Re: Response to Submission - Proposed Bringelly Road Warehouse and Distribution Facility (SSD-37558583)

Ian Stendara
Executive Planner

Attachment – Detailed comments

LANDSCAPE PLAN 01

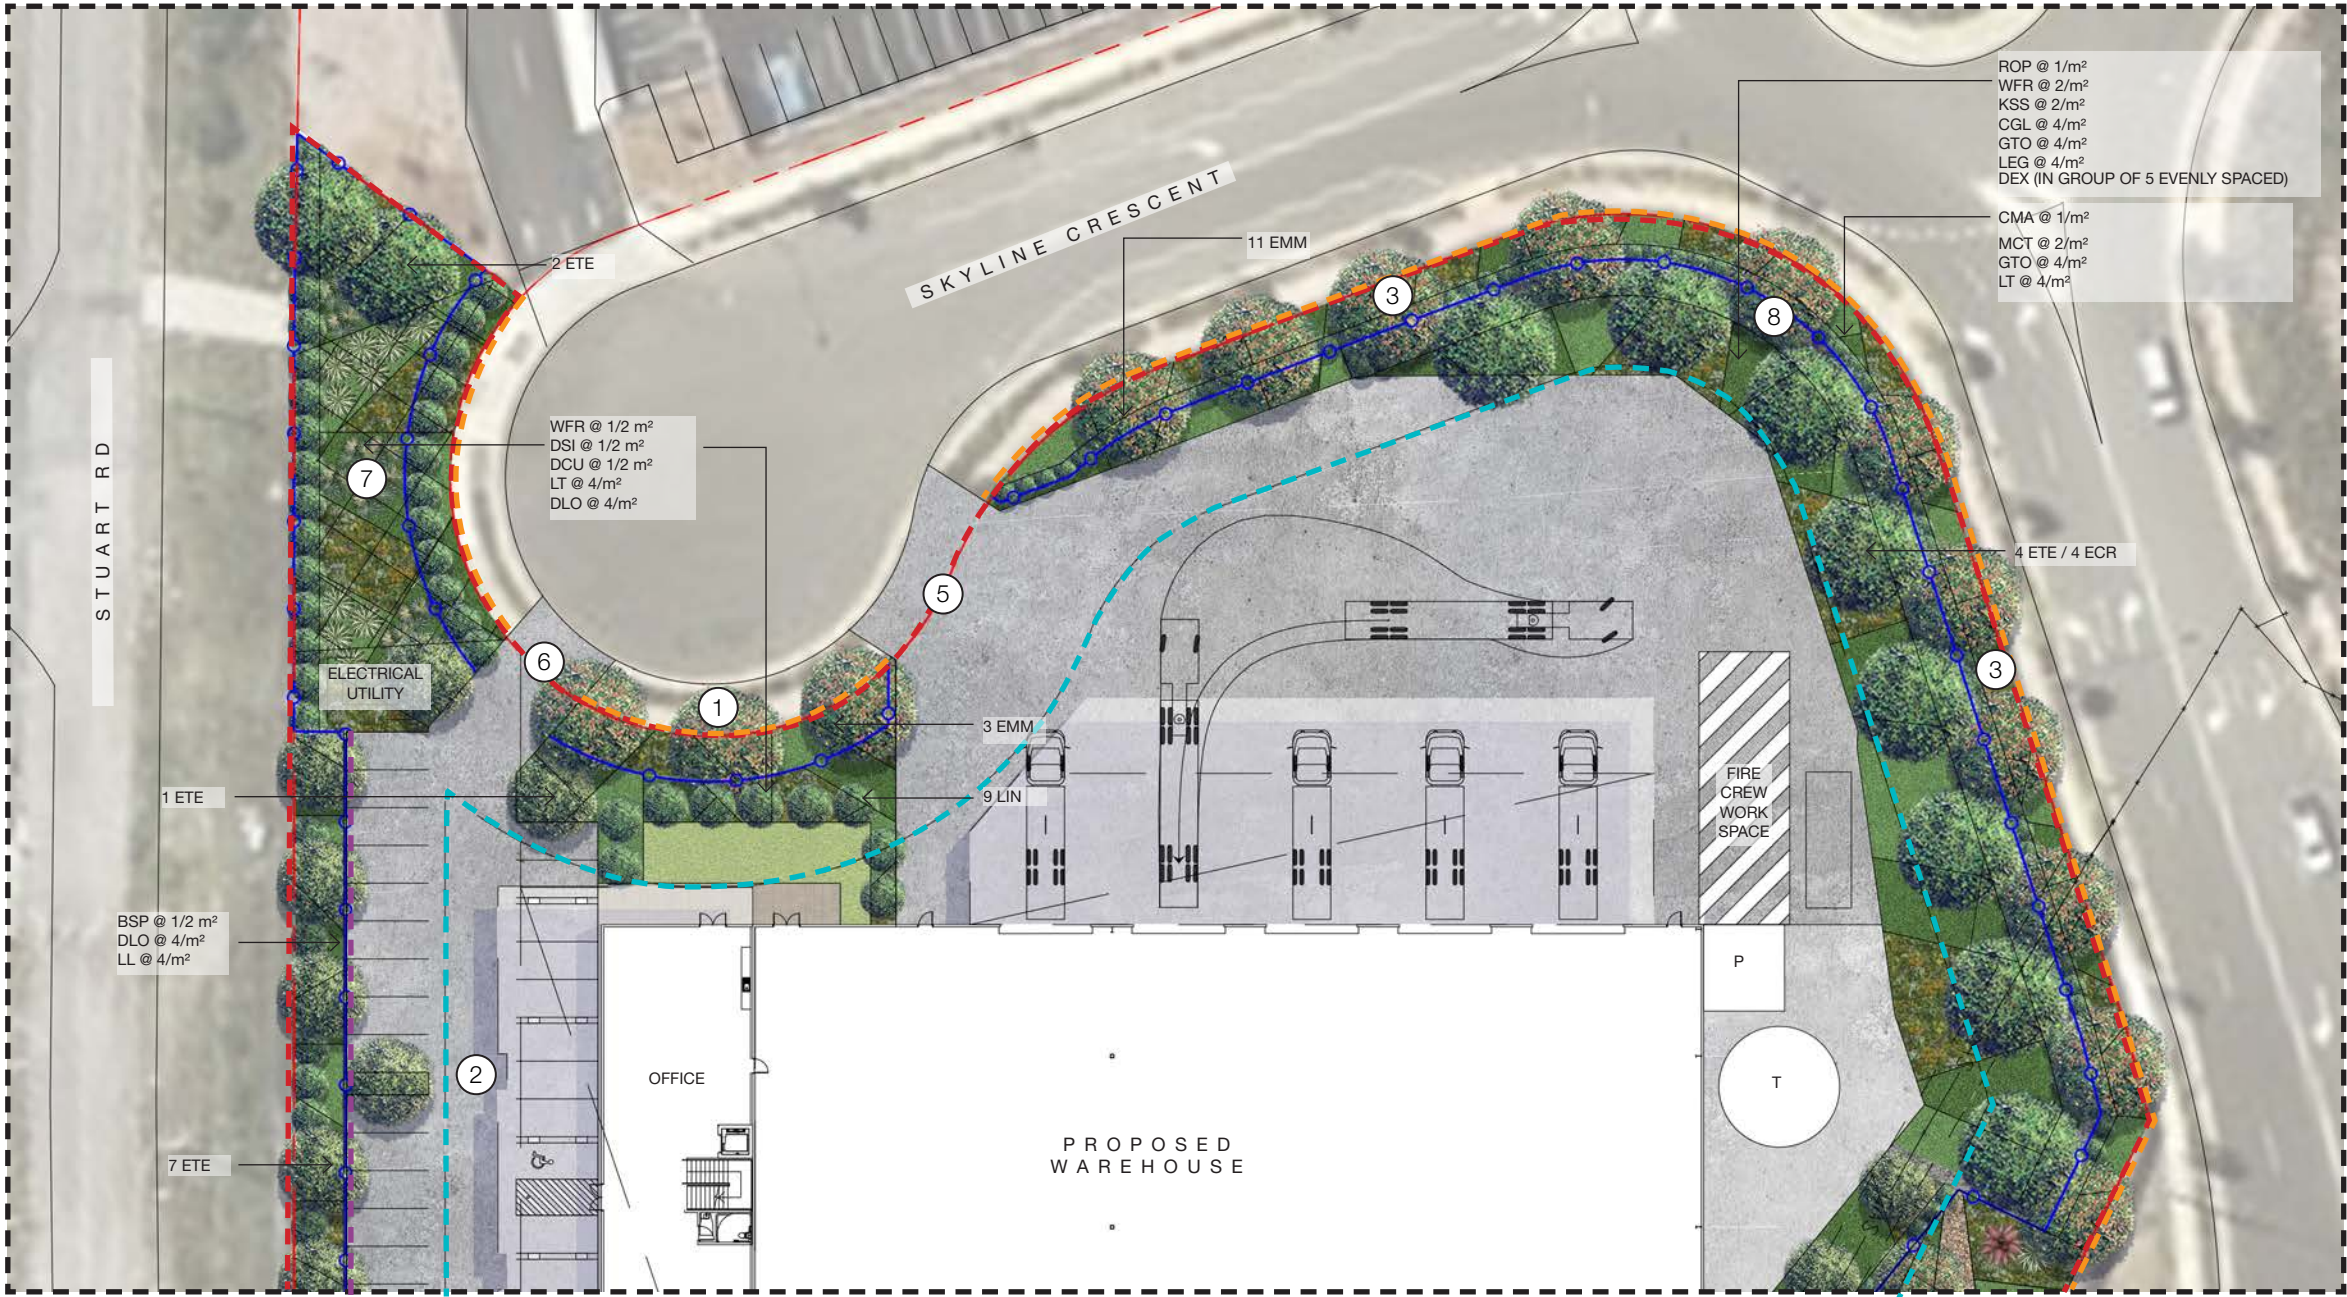
The proposed development will contribute to the ongoing transformation of the area from its rural character to urbanised one. Planting of additional street trees in the verge adjacent to Bringelly Road and Stuart Road will support the urban landscape and reduce the impact of urban heat.

The height of the palisade security fence needs to be 1.8m to comply with the requirement of Liverpool DCP and to be consistent with similar development in the LGA.

The quality of the outdoor amenity space needs to be detailed in regard to its functionality and purpose it serves to the proposed warehouse. There is potential risk that this space may become neglected and unused for its intended purpose.

3. Additional street trees to be planted in the verge adjacent to Bringelly Road and Stuart Road to support urban landscape of the subject site and to reduce the impact of urban heat.

4. Permeable paving in the car park be integrated to reduce the urban heat island effect.
5. The height of the palisade security fence be 1.8m to comply with the requirements of Liverpool DCP and to be consistent with the similar development within the LGA.

6. The sprinkler tank be screened through the integration of public art to reduce the visual impact onto the public domain.
7. Landscape and Architectural Plans be updated to reflect the use of the proposed outdoor amenity space, including provision of outdoor furniture and other amenities to support the use of the space as a lunch area for future employees.
